RE: VILLA PALOMAR PHASE III, (D19-D13B) SUBMITTAL RECEIVED MAY 20, 1993
FOR GRADING PERMIT APPROVAL, ENGINEER'S STAMP DATED MAY 20, 1993.

Based on the information provided on your submittal, the above referenced grading plan is approved with the following understanding:

GRADING PLAN : VILLA PALOMAR - PHASE III

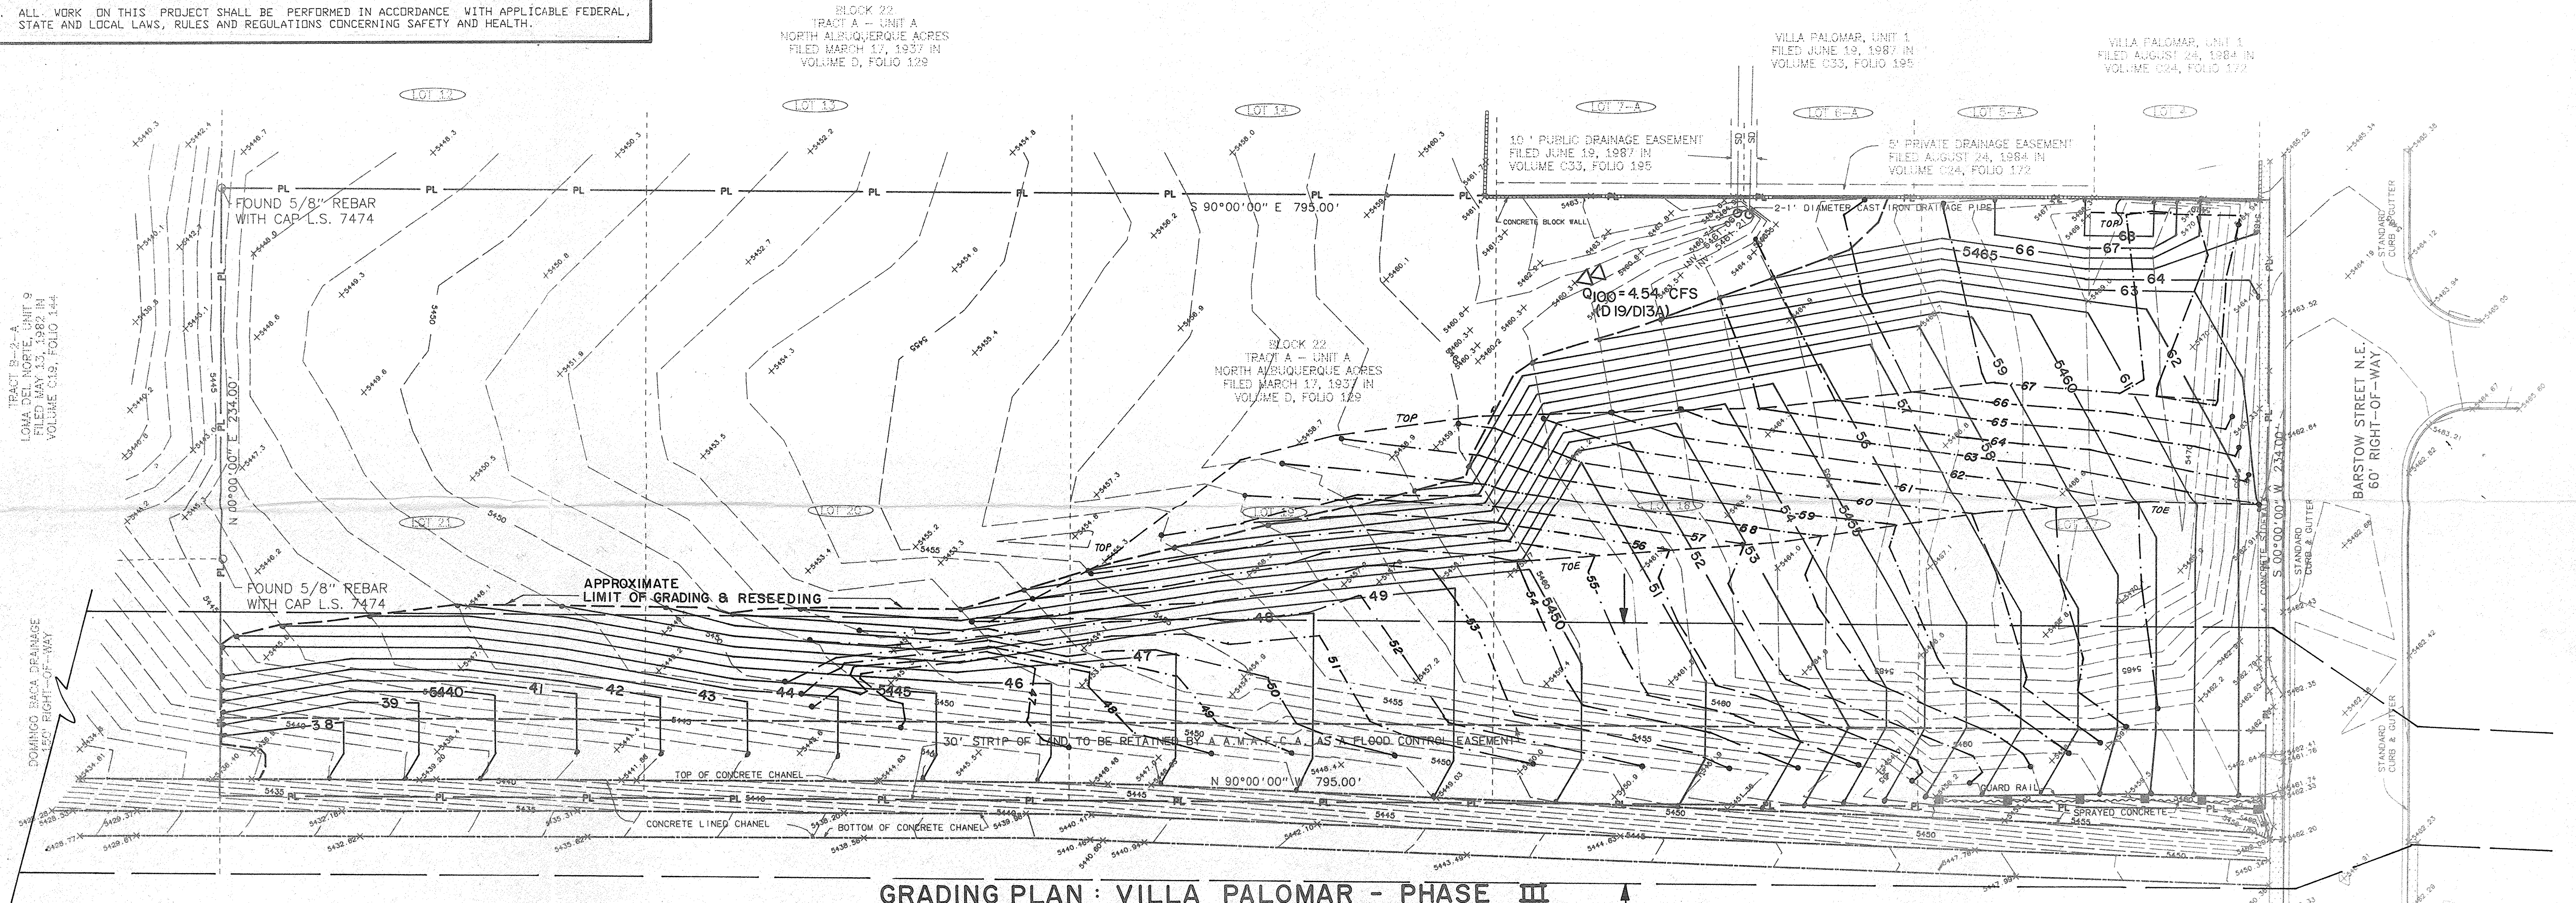
Mortensen & Associates will update the drainage plan, using AHYMO, to confirm the off-site flows. The plan will include the existing floodplain as shown on panel 10 of 50 of the FIRM map. These updates can be incorporated with the certification submittal. I might add the certification will be per the DPM checklist.
